## 211 Danforth St - restaurant/deli building permit

**Subject:** 211 Danforth St - restaurant/deli building permit

I've taken a look at the permit application for the restaurant fit-up at 211 Danforth St. I apologize for the long delay.

A2-0

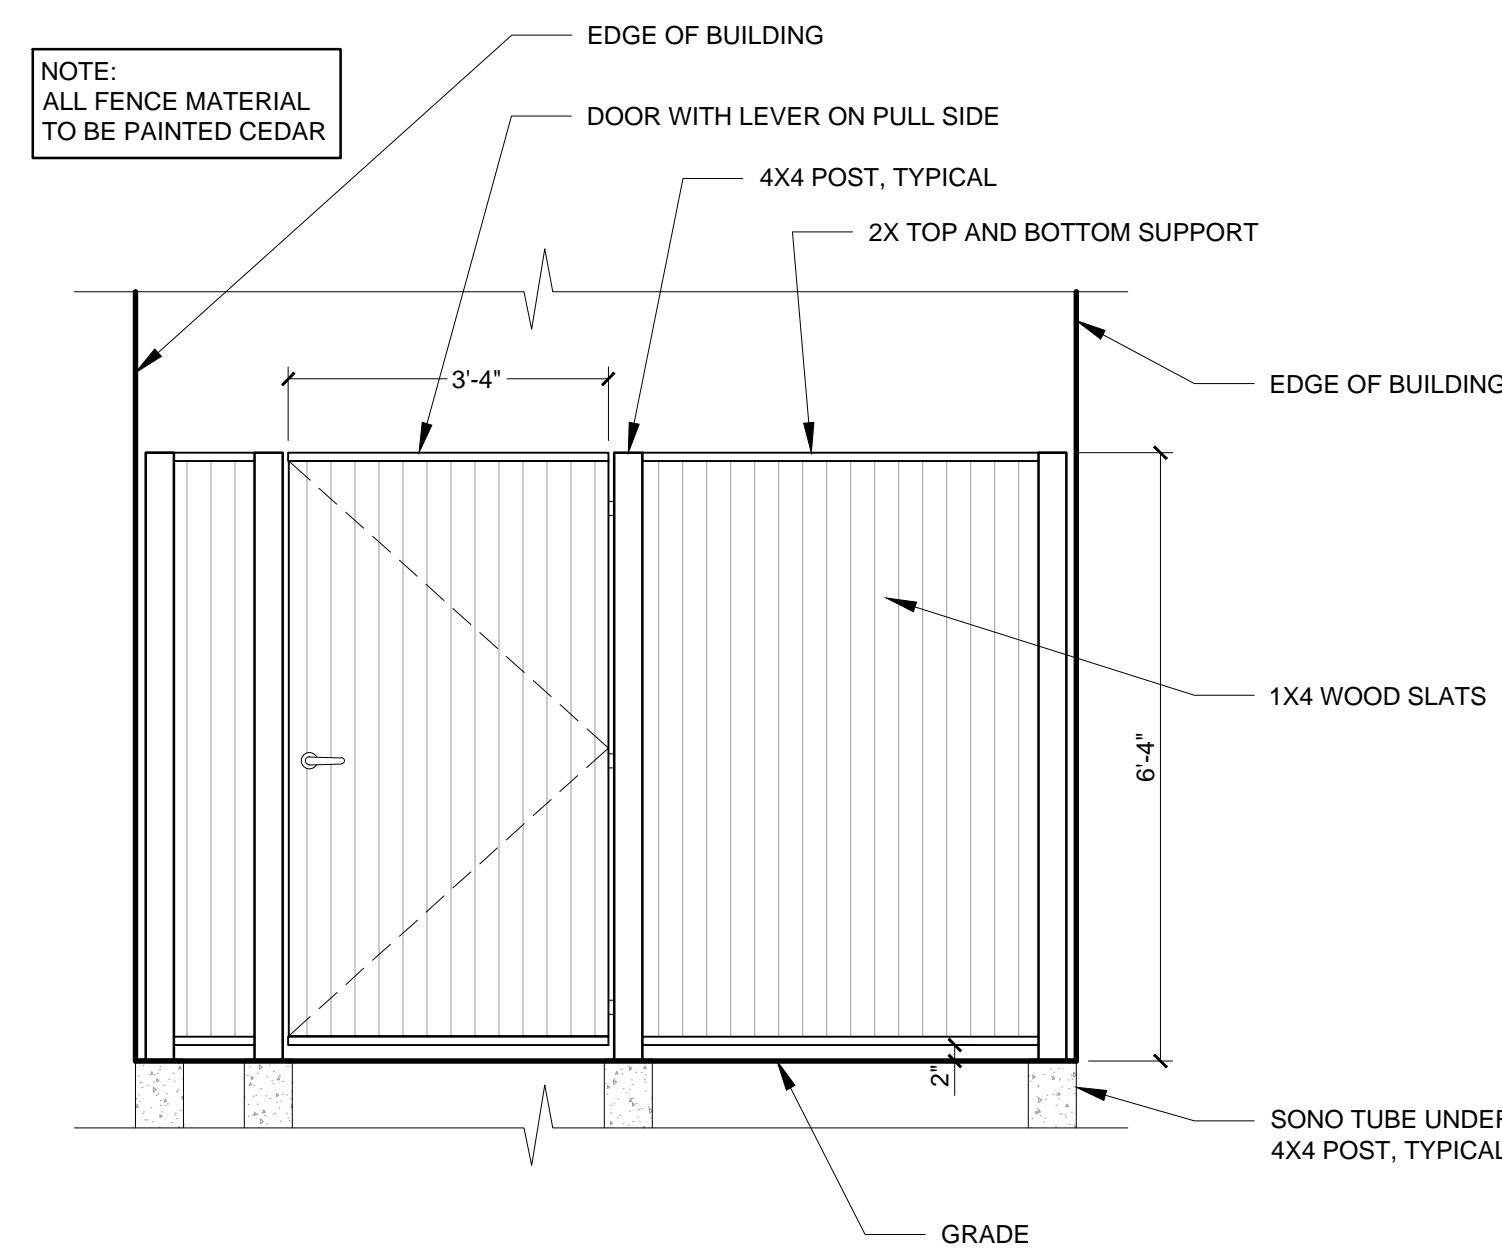
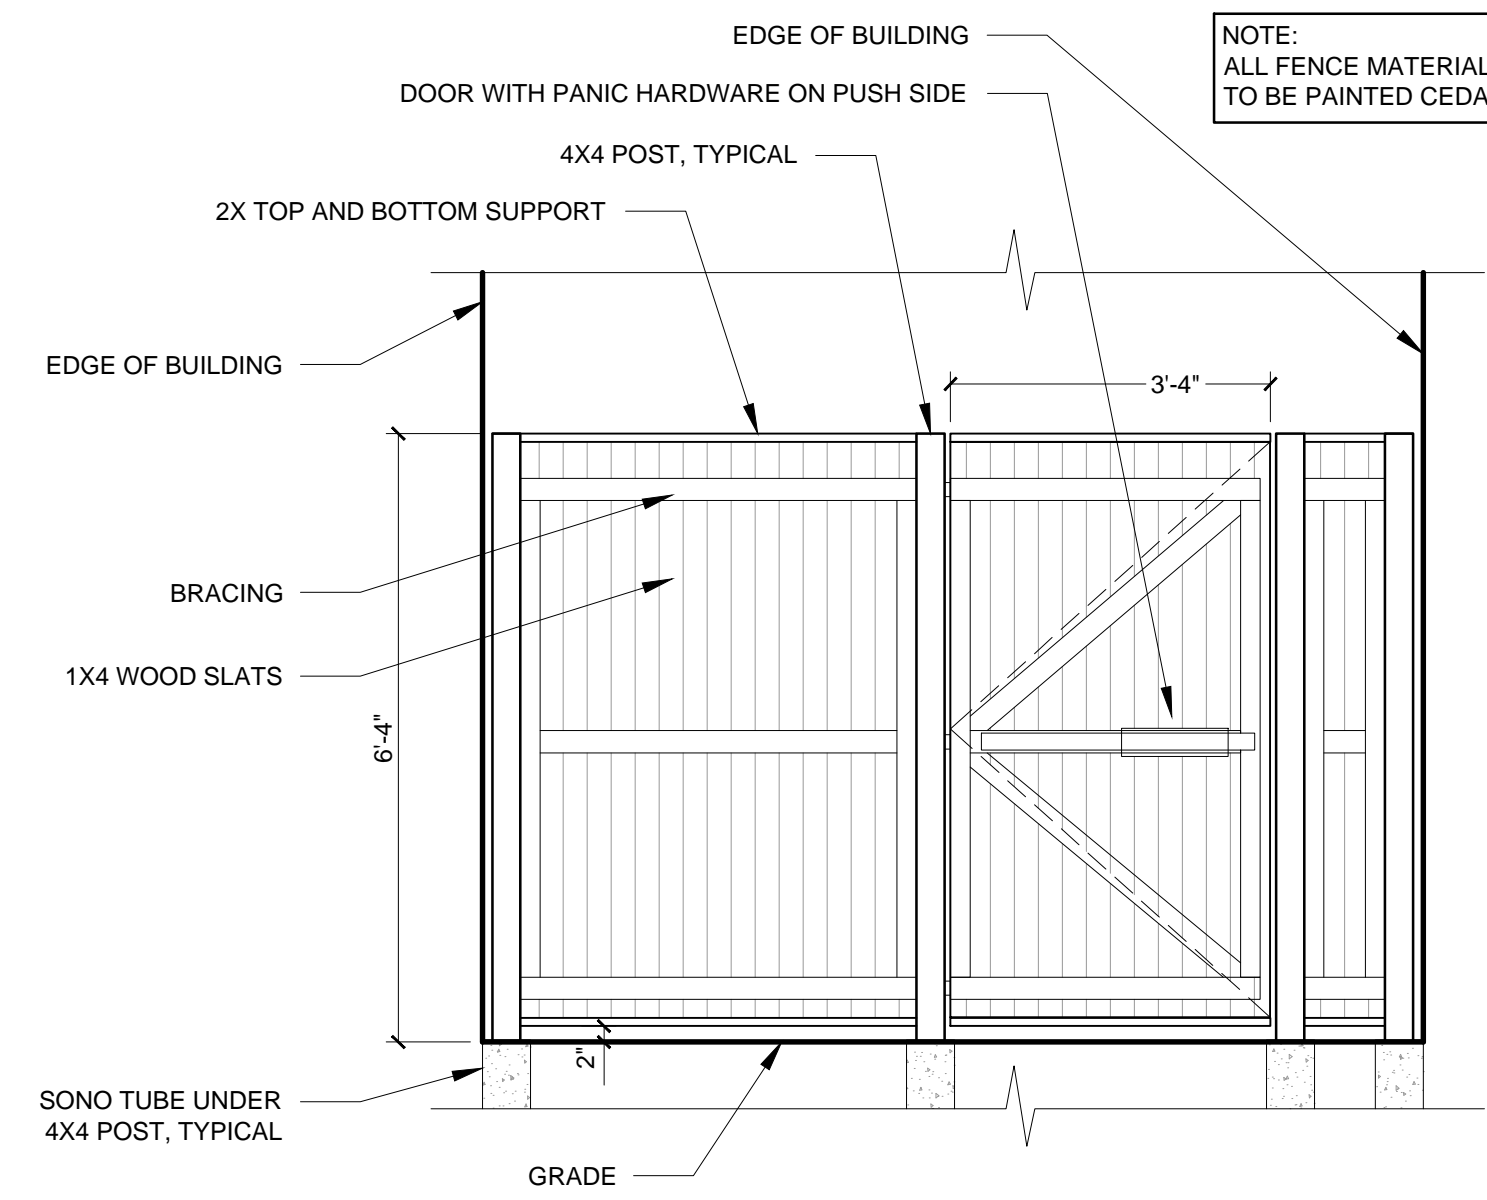
One quick question - is the fencing still proposed at this time, or is that also withdrawn?

There is presently a fence there but the idea was to install a new more decorative which they would like to do in the spring first prior to any of the other site improvements. Thank you.

A5-0

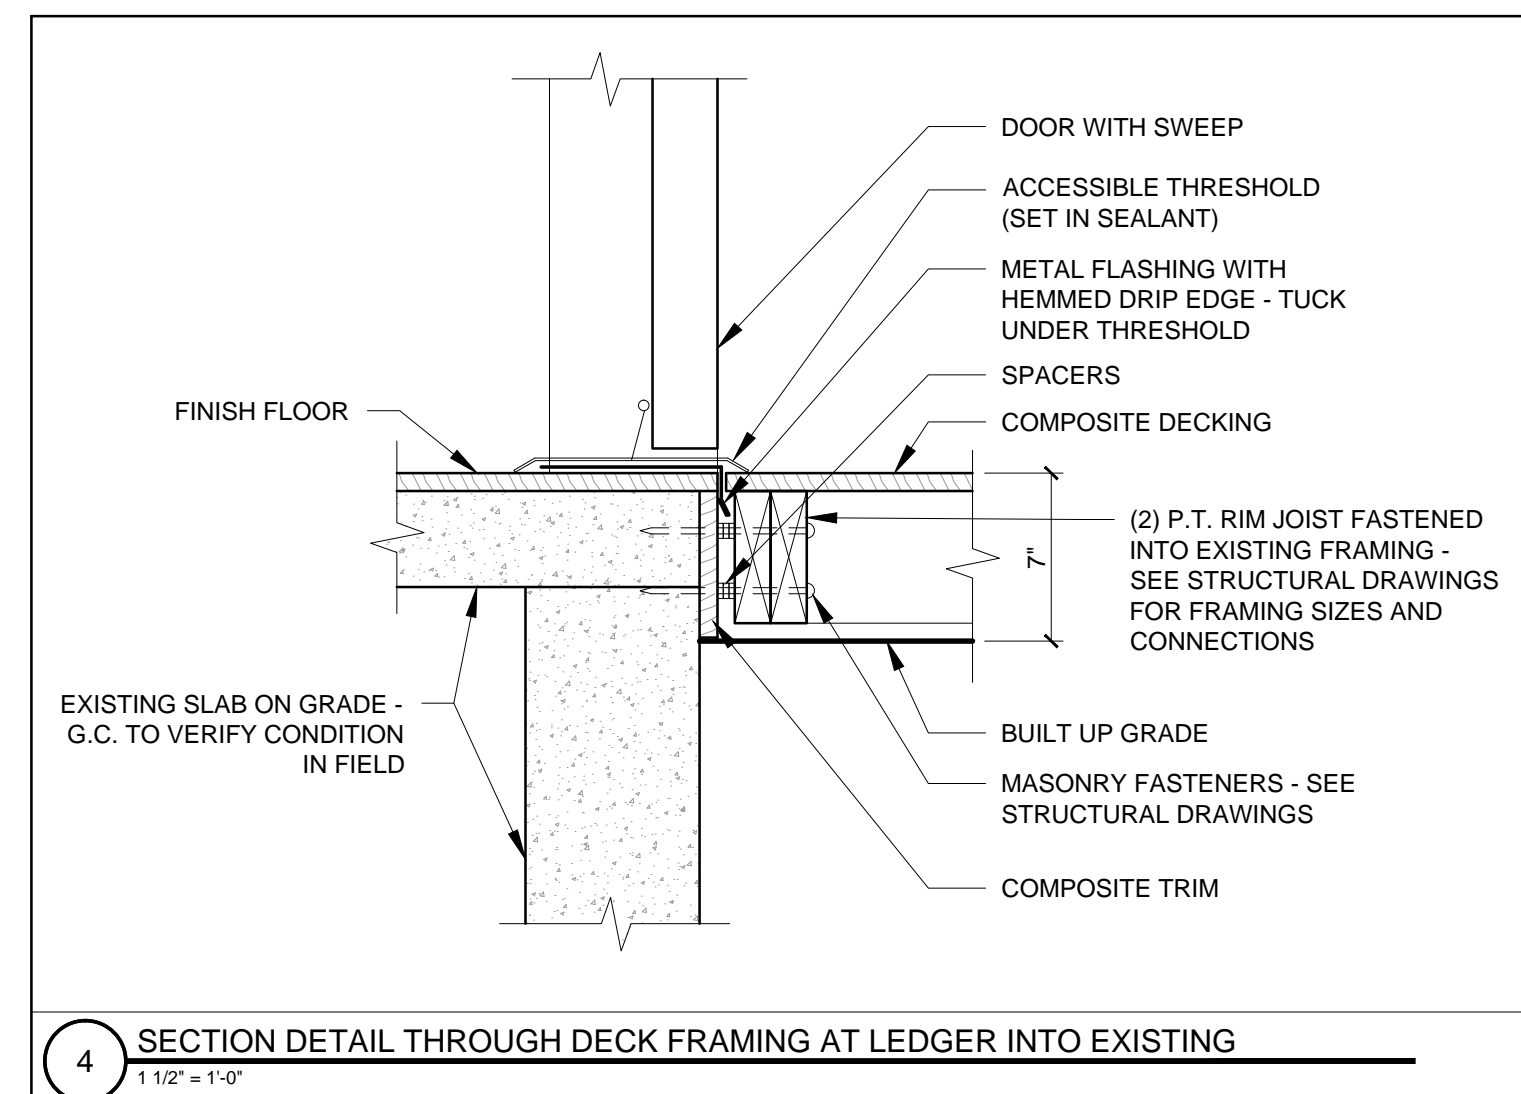
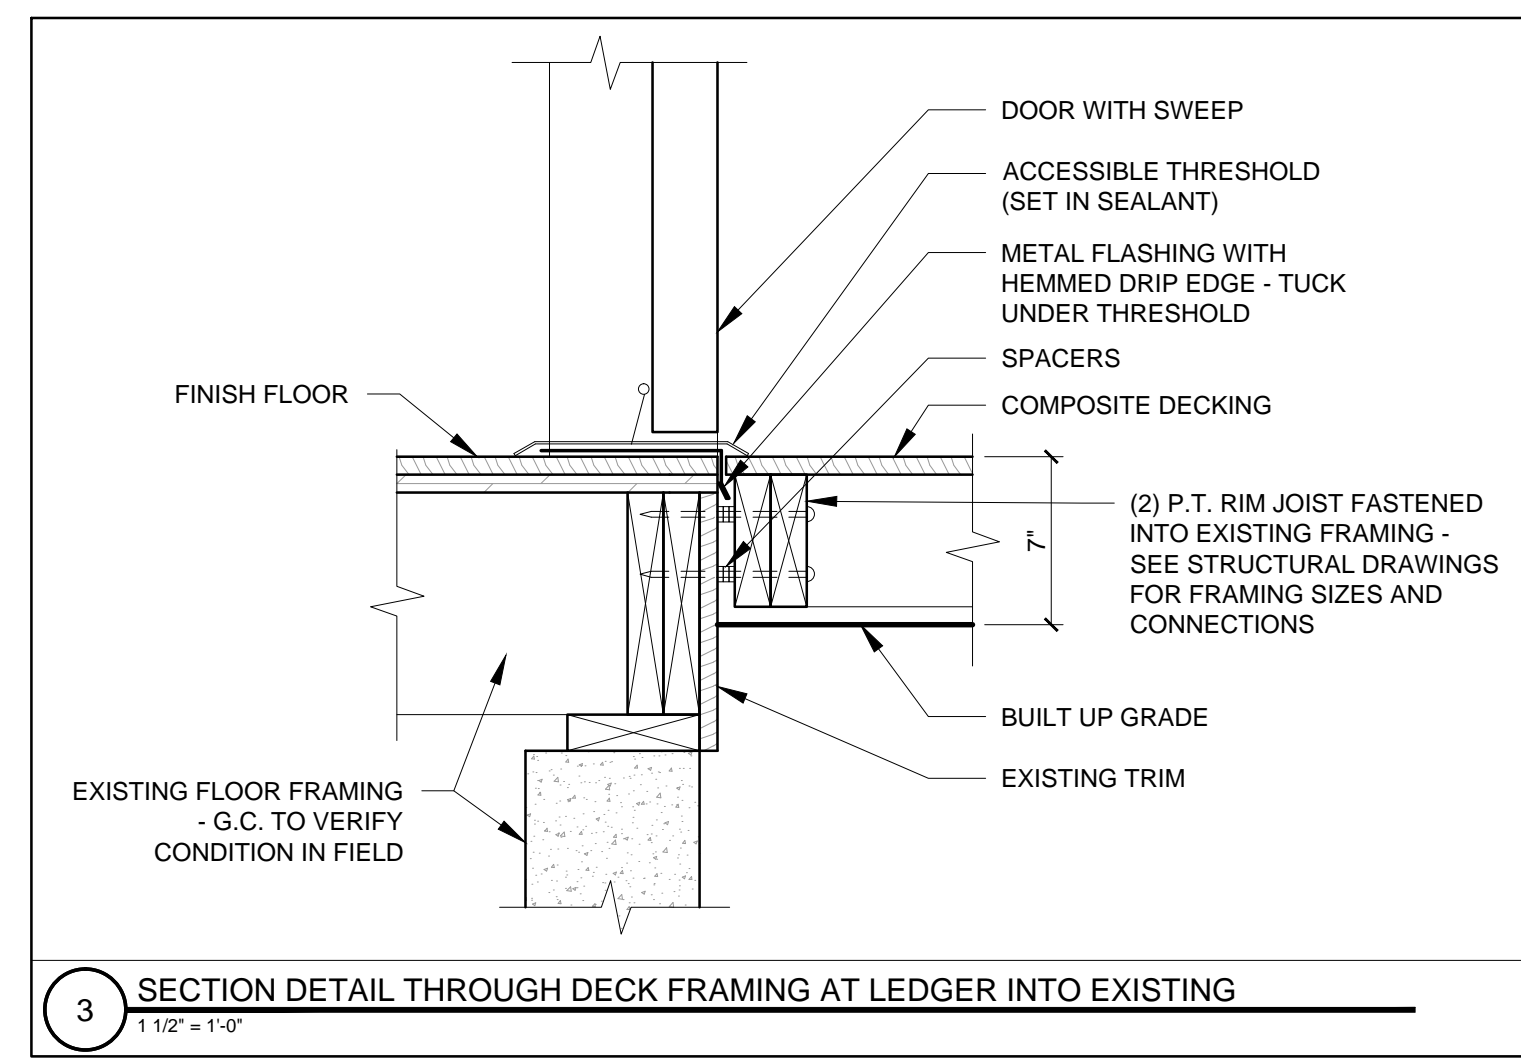
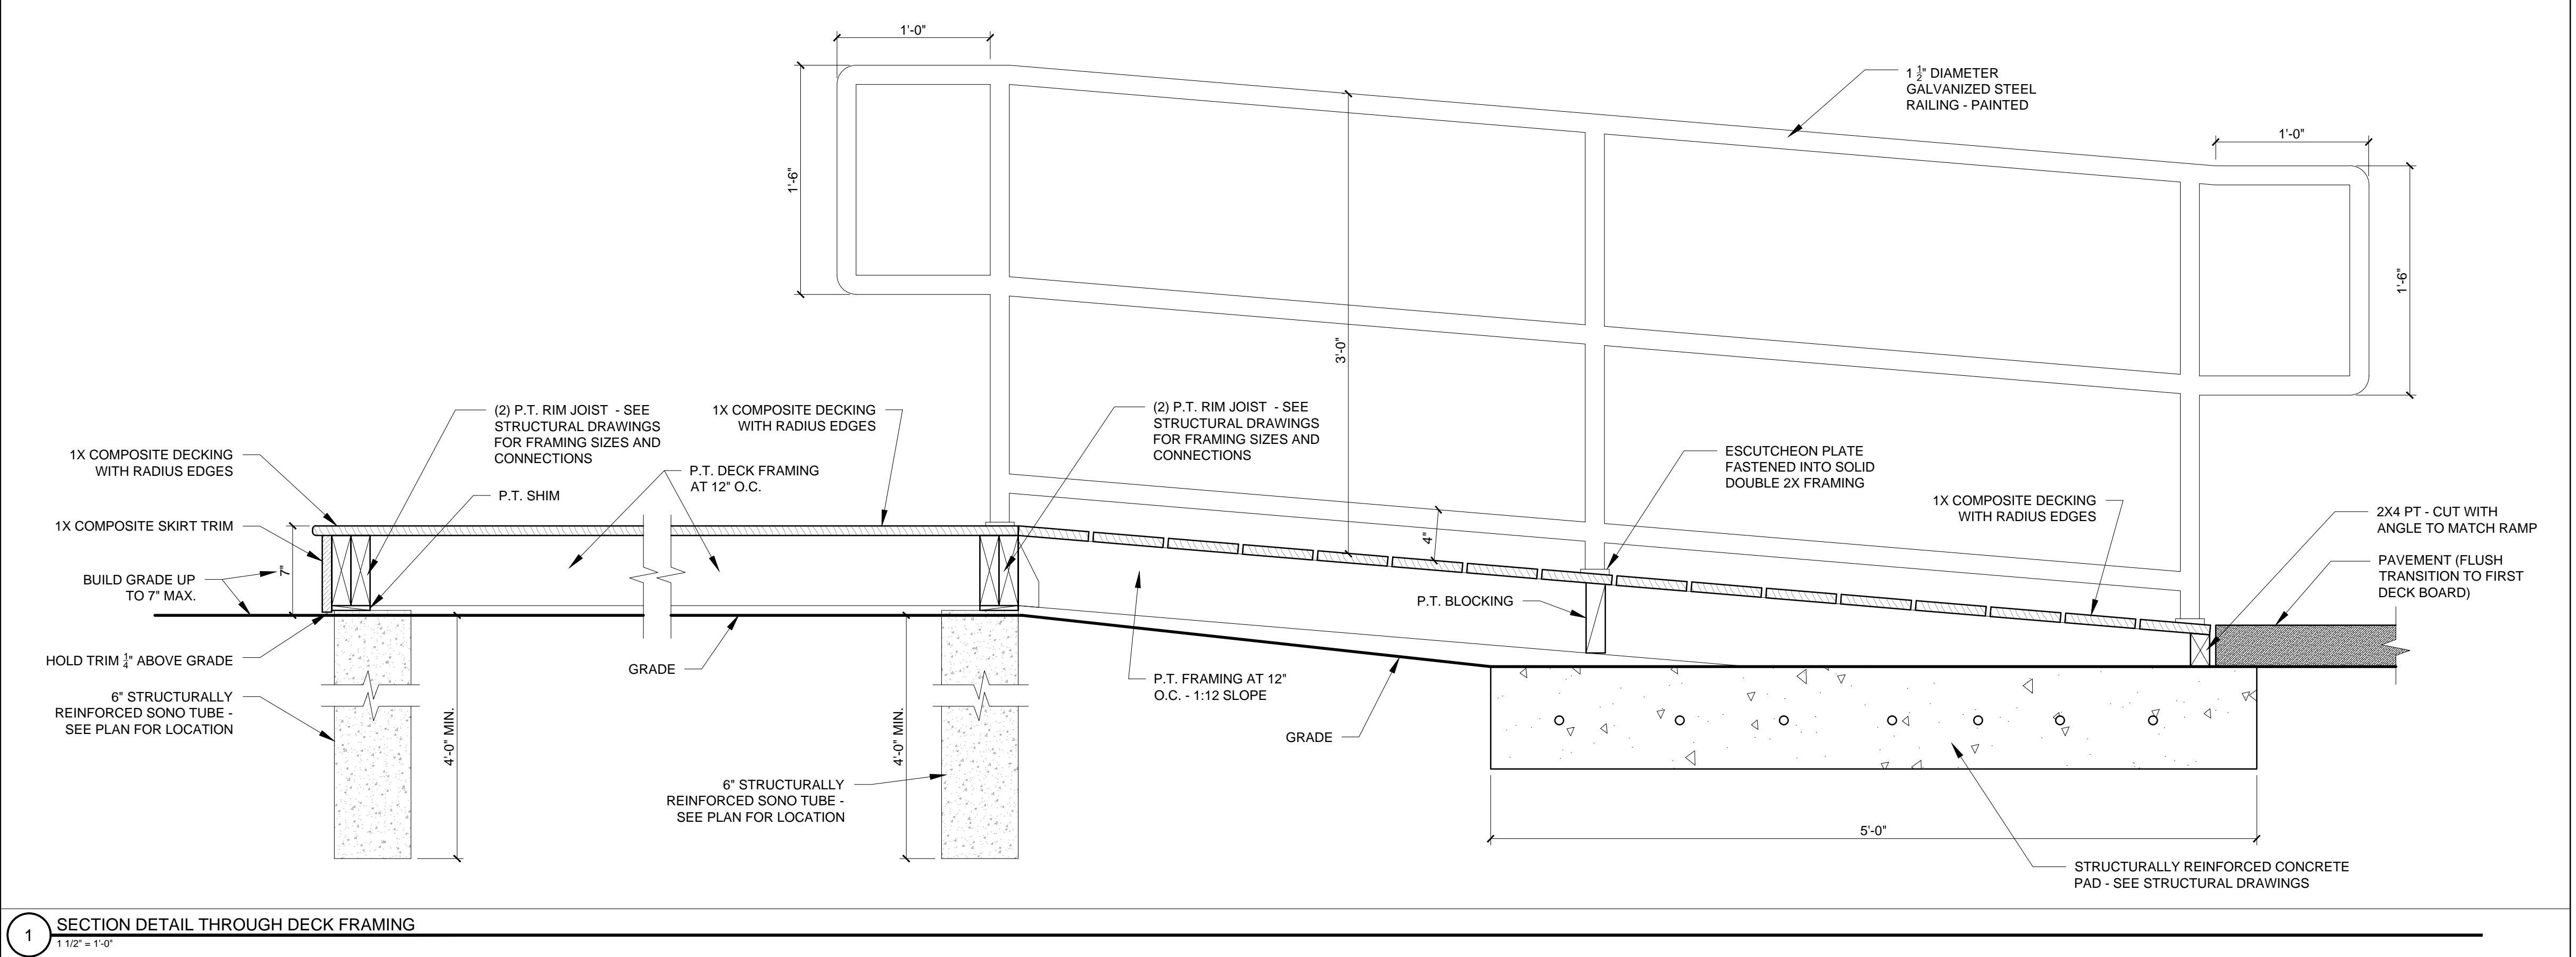
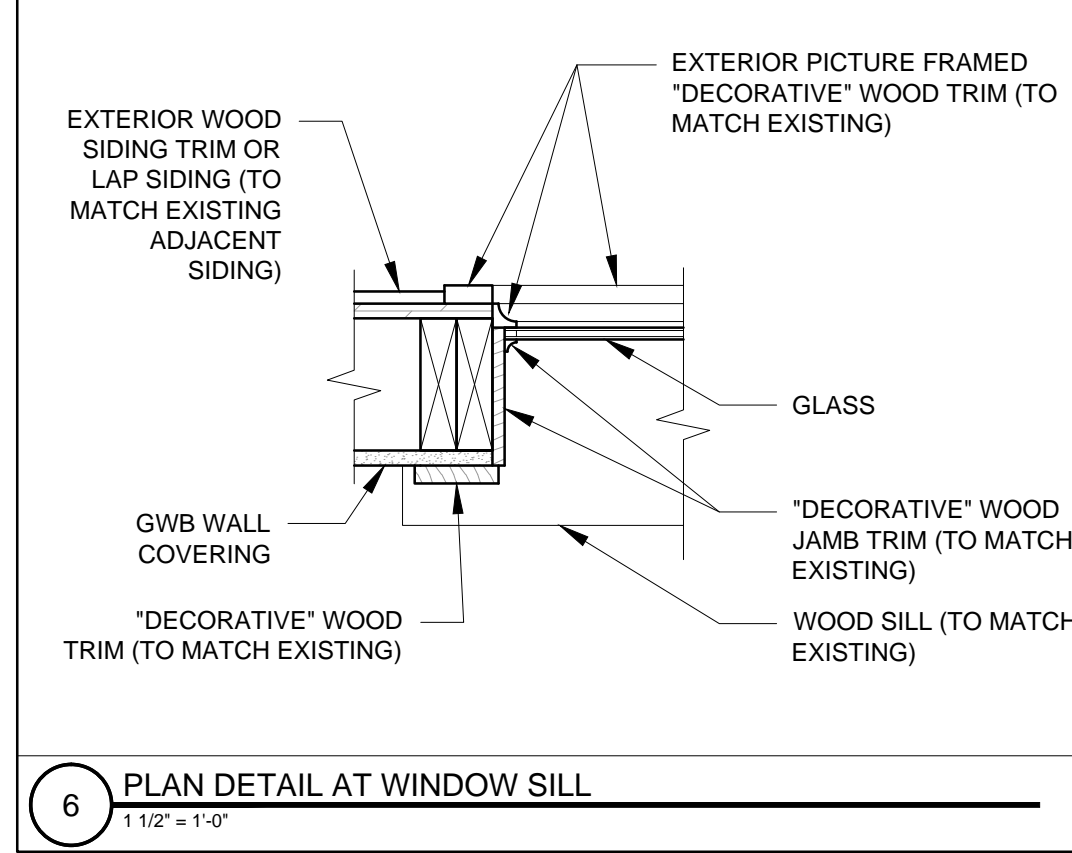
There is one item I need some more information on. The plans show a new deck & ramp being constructed. I need some sort of plot plan showing the following:

- 1) That the deck will meet the required rear setback of 10 feet.
- 2) That all impervious areas (pavement and buildings) do not exceed 90% of the total lot area.

Thank you for this information. Is there a ramp installed yet, or do you have plans for what is intended be installed? Even temporary ramps require a building permit. I am not sure if you want to include it in this permit, or apply separately in the future.

We have reviewed with the designers and Owners and have decided to forego that plan for now and revisit in the future when they get more revenue to rework the entire back patio and deck. We are using a temporary/mobile ramp system for ADA compliance when required. Thank you.

The below is what we will use and will remove or set on a case by case situation. It will not ever be permanent and will only be used when a handicap patron comes to the restaurant. We will purchase this anytime but have not. We can do it anyway your prefer. We have used these on other projects with non-compliant historical existing conditions and had not been required to get a separate permit. we can do what you need. Thank you!
